CITY OF ALBUQUERQUE

Re: ABB ABQ Addition
6625 Bluewater Road
Traffic Impact Study
HT#K10D011
Engineering Seal date 11/02/2023

Review of the ABB Expansion Traffic Impact Study dated November 2023, received November 2, 2023 has been completed by the City's Planning Transportation Development section. Please address the City's comments as well as any from the NMDOT and resubmit the report for approval. The City has the following comments.

ABB EXPANSION
ALBUQUERQUE, NEW MEXICO
BLUEWATER RD & COORS BLVD PROPOSED STRIPING

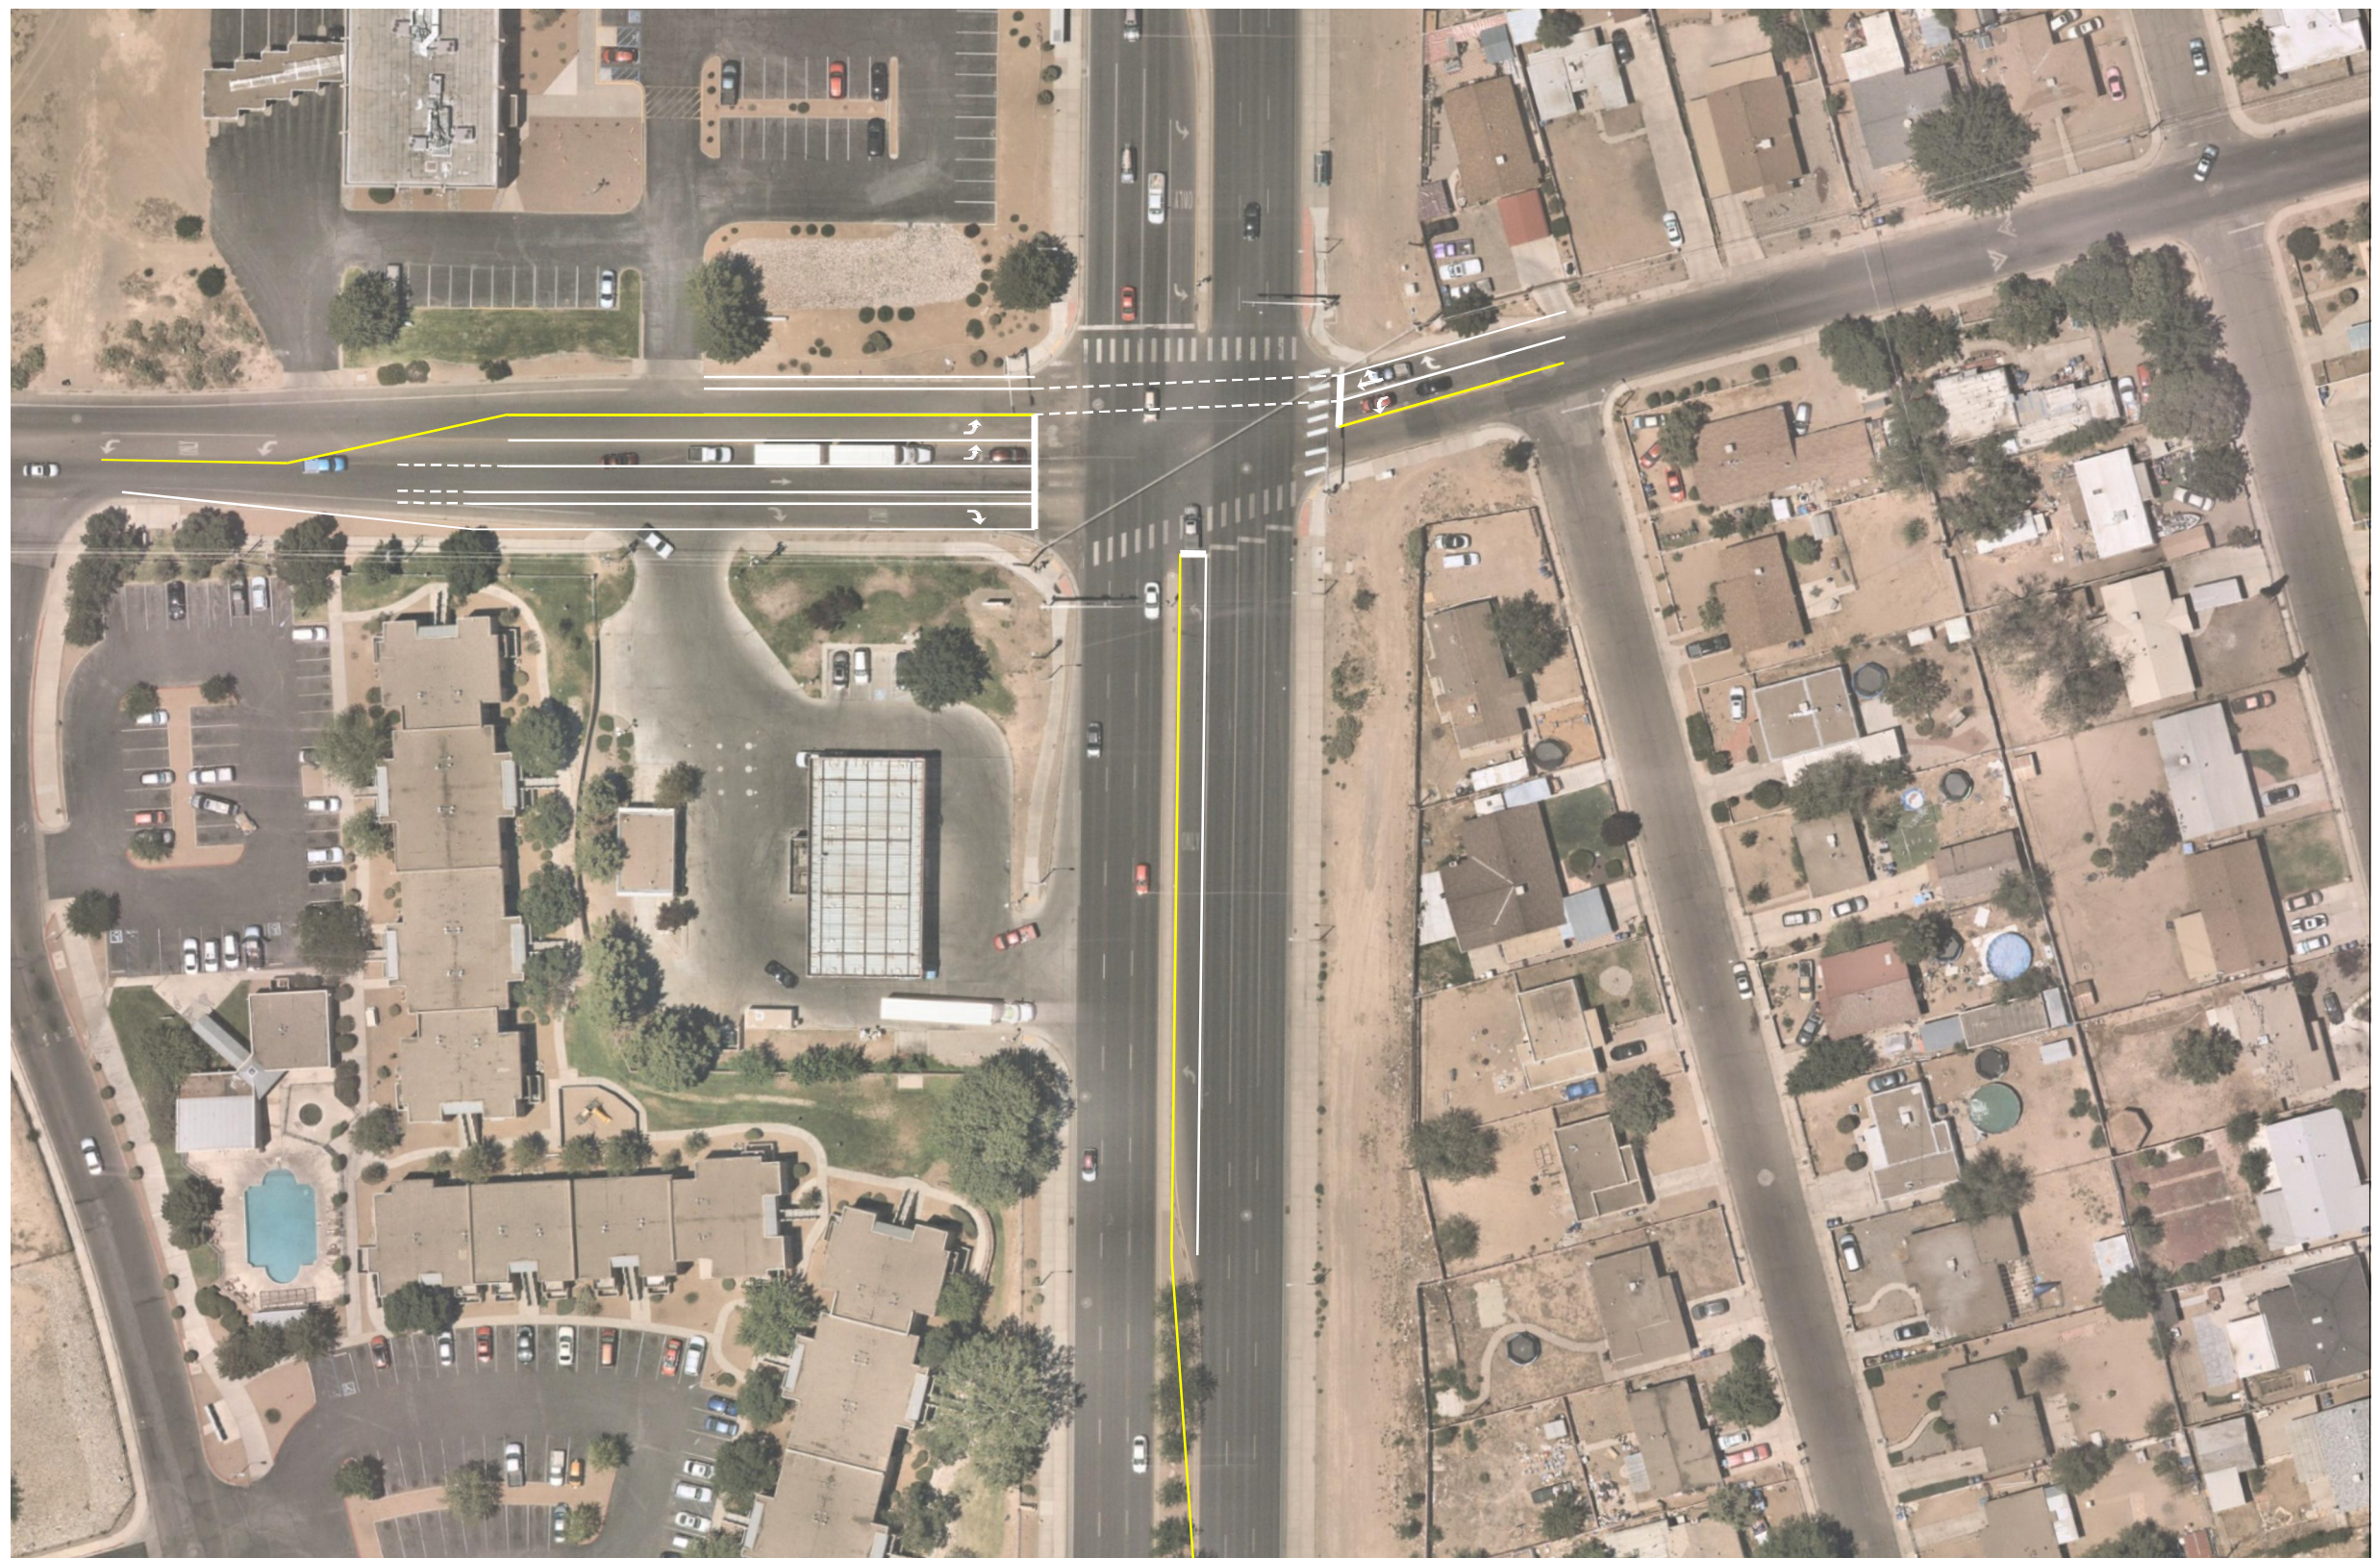
2. The eastbound right-turn lane on Bluewater approaching Coors Blvd. should be reconstructed extending and removing the taper transition to the turn-lane. The left-turn lane for this approach should be extended. The development contributes a small percentage to these movements. The future reconstruction, no project currently planned, of the right-turn lane will not be the responsibility of the development except any pavement striping/markings, and signs required due to the reconstruction. The City asks the developer to provide infrastructure improvements at their expense for the restriping and required signs for the existing right and left turn lanes.

FIGURE 7
ABB EXPANSION
ALBUQUERQUE, NEW MEXICO
2025 IMPLEMENTATION YEAR TOTAL TRAFFIC VOLUMES

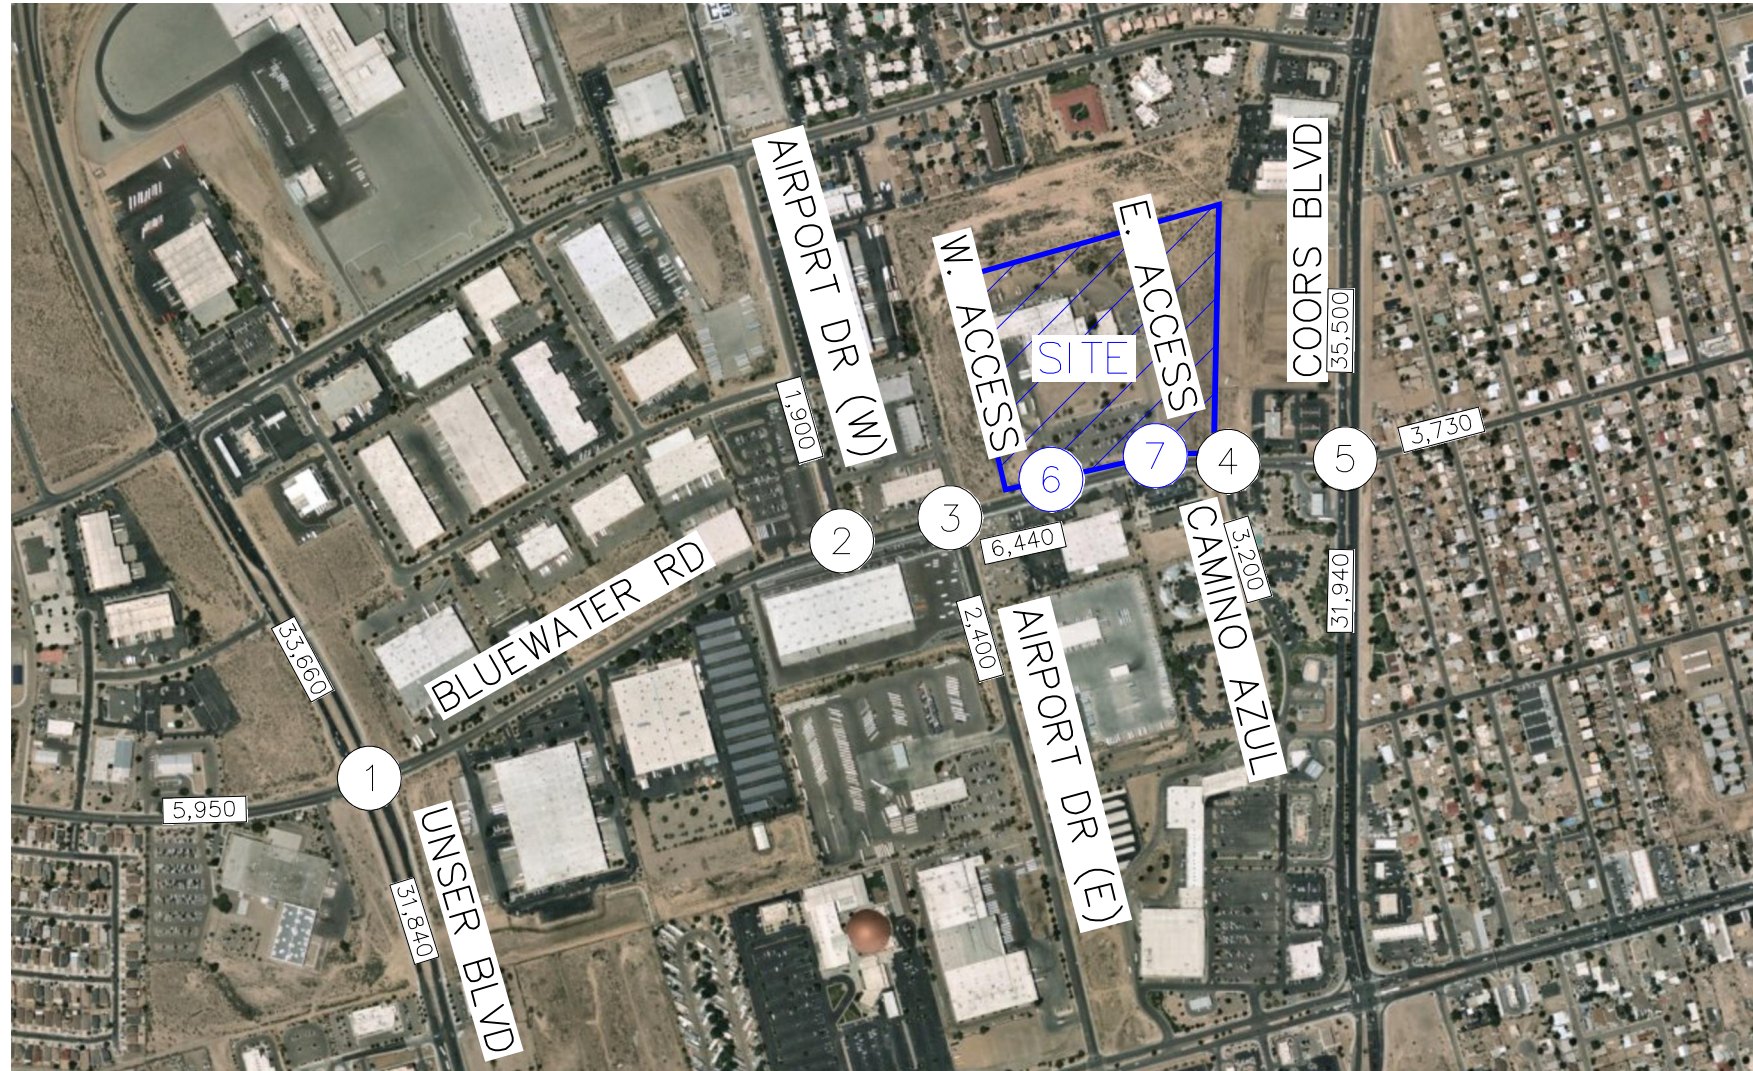
1. The 2025 Implementation Year AM peak hour traffic volume for the westbound right turn movement at the Bluewater East Access to the development traffic exceeds the City's warrant threshold for right turn lanes, see COA DPM *Table 7.4.67 Turn Lane Warrants*. Assess the available Right-of-Way for a westbound right-turn lane at the East Access. Provide a recommendation for the right-turn lane geometry that will fit within the available ROW. The City is willing to accept a reduced length if the existing ROW is limited. A sidewalk easement may be required.

FIGURE 9
ABB EXPANSION
ALBUQUERQUE, NEW MEXICO
RECOMMENDED GEOMETRY AND CONTROL

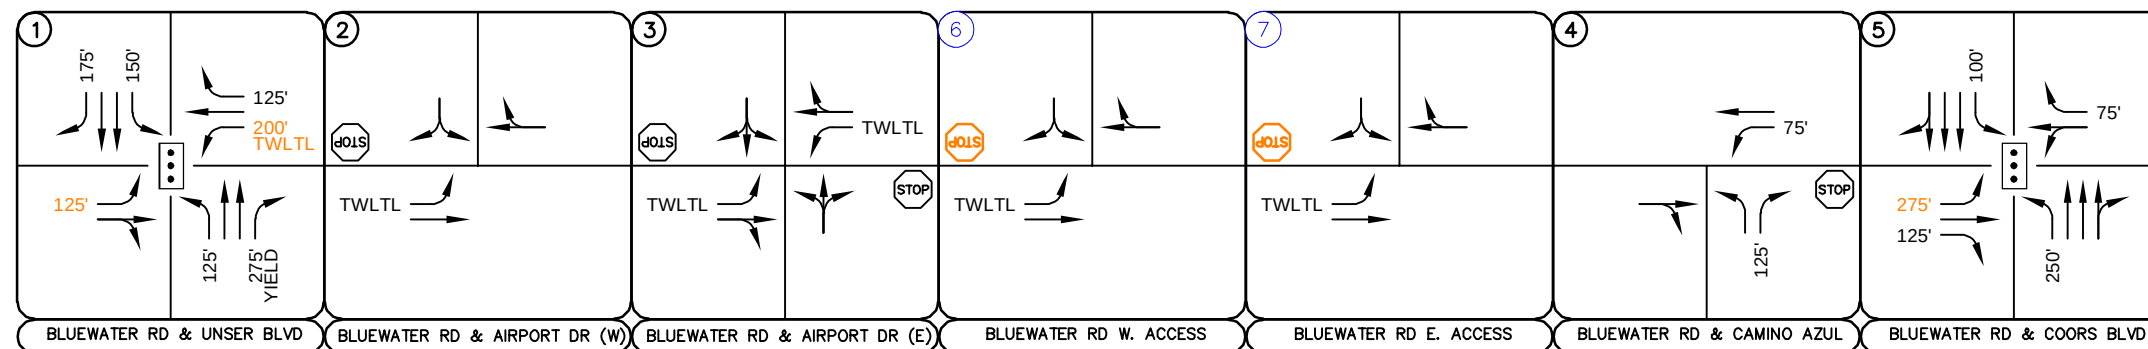
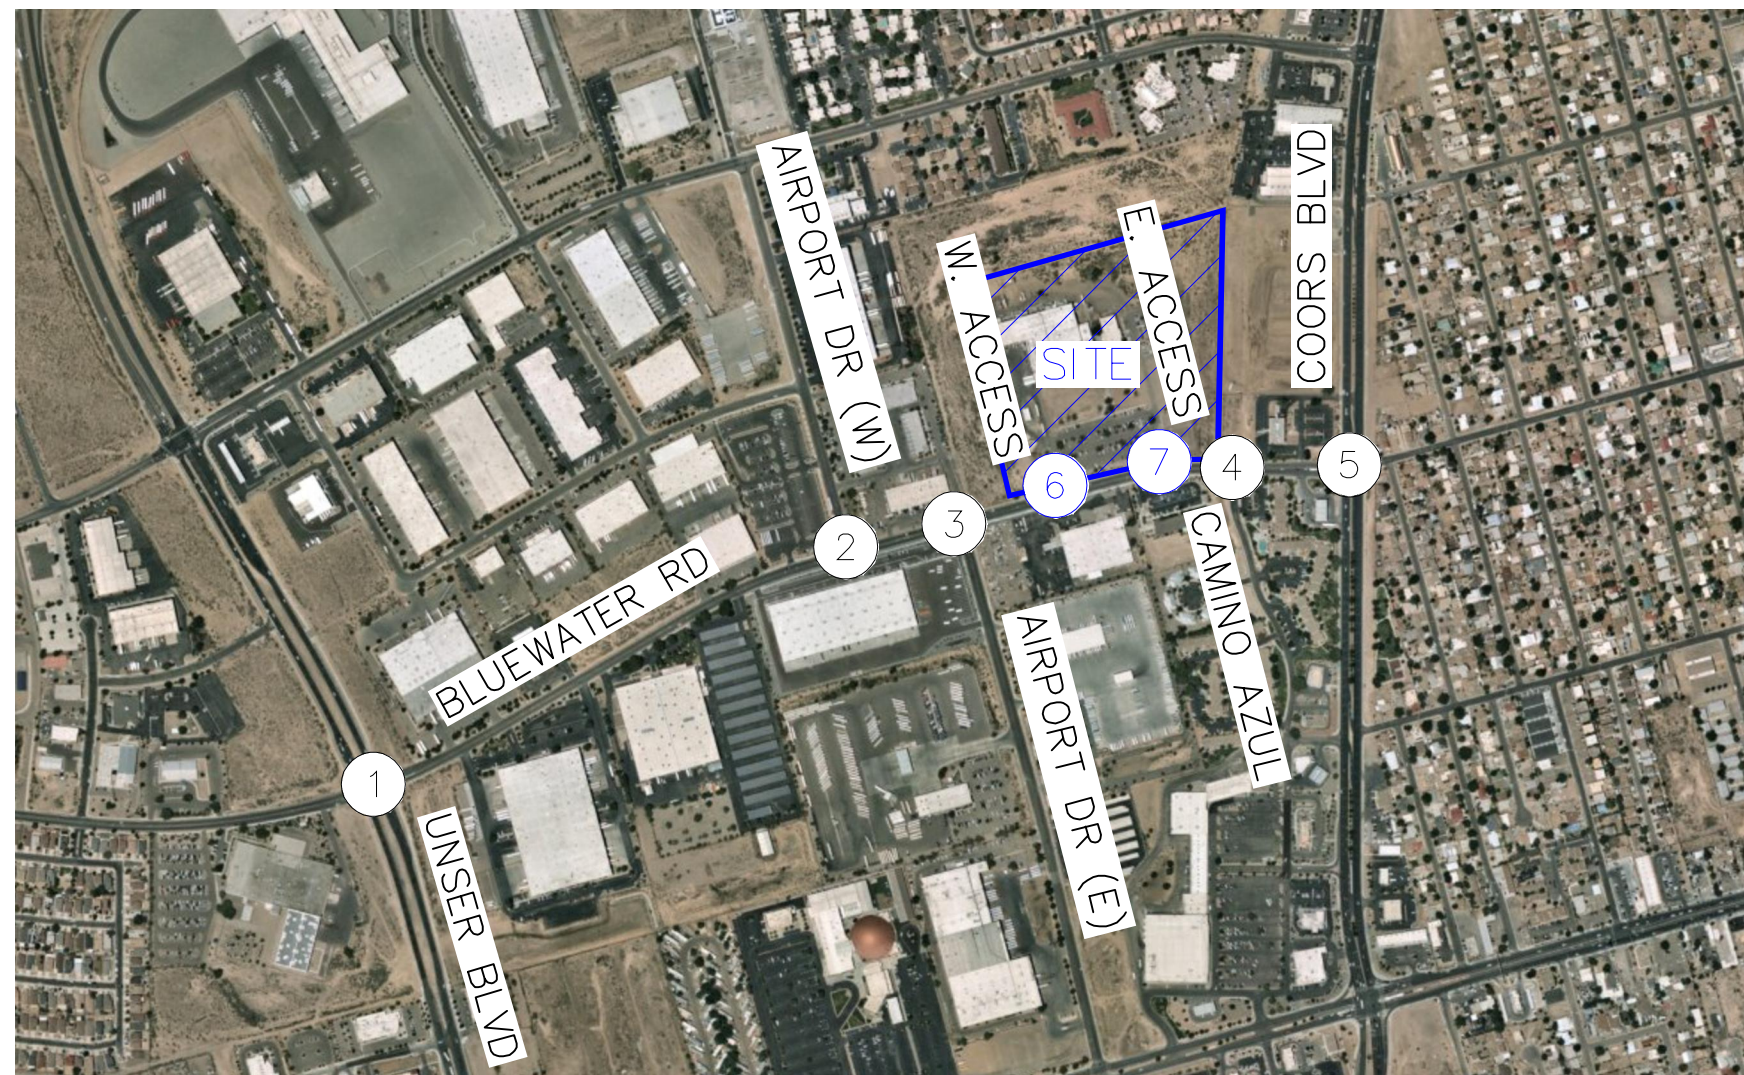
3. The Bluewater westbound approach to Unser left-turn lane should be extended.
